3980 Walker Road Final Drainage Report

Subdivision: Walker Reserve (Lot 3)

Date Prepared: June 2024

PCD No. PPR2350

PROPOSED SWALE DETAIL
 NOT TO SCALE

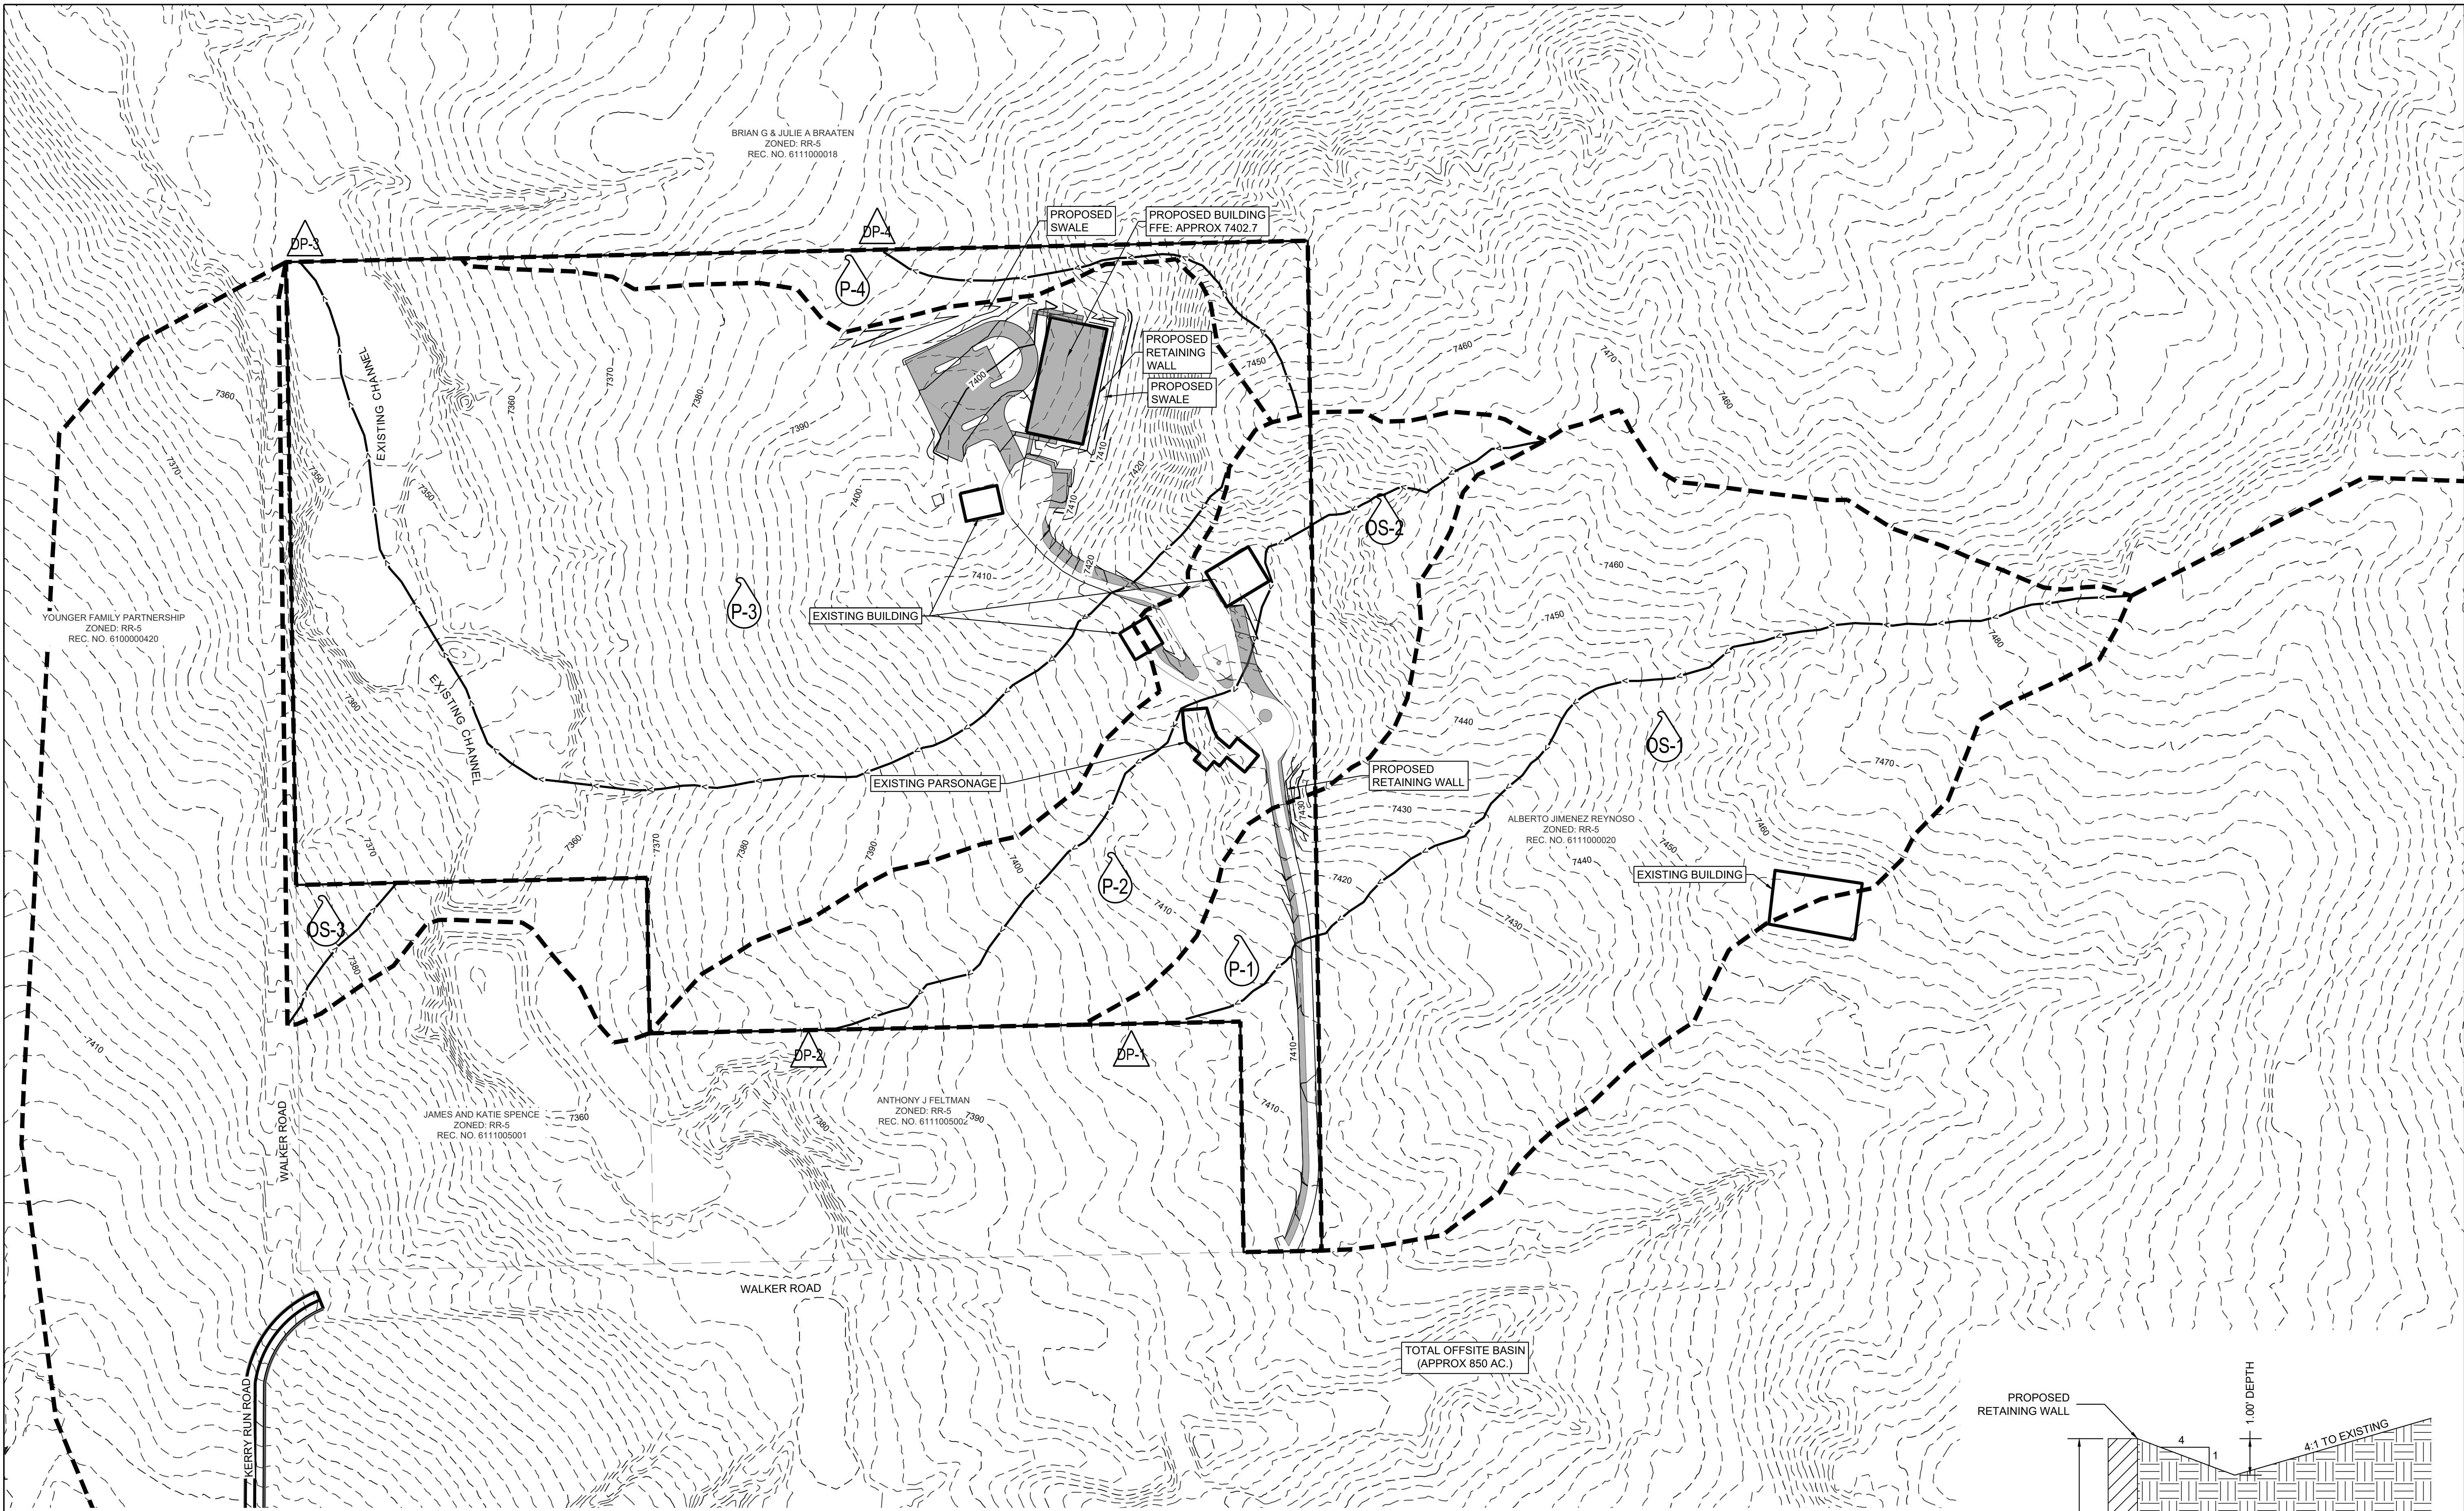
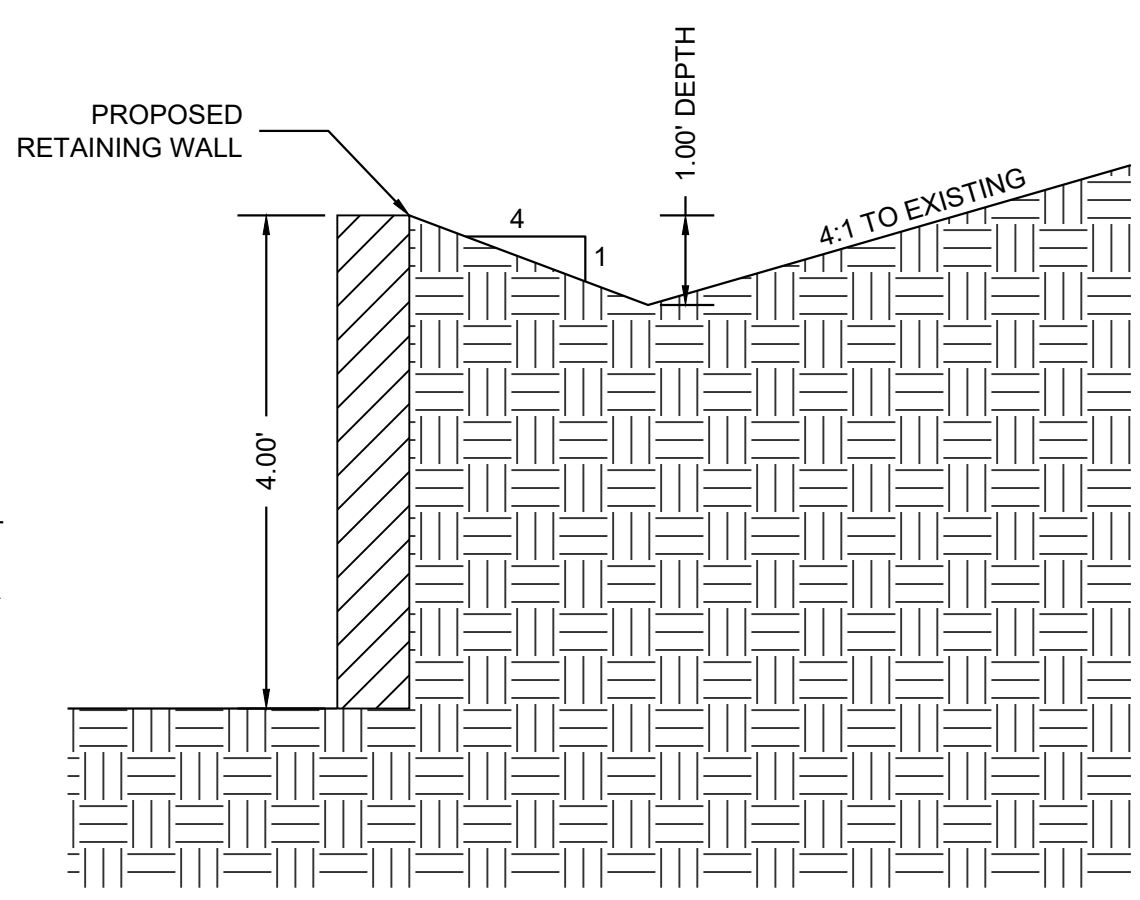
Runoff Reduction calcs and map are provided on pages 43 and 44 below but are not discussed in the report text at all. Please discuss in these sections and anywhere else you deem appropriate. As-is, it's confusing to state that the site is excluded from needing WQ but then provide WQ calcs. You can just state that those calcs are provided for reference only.
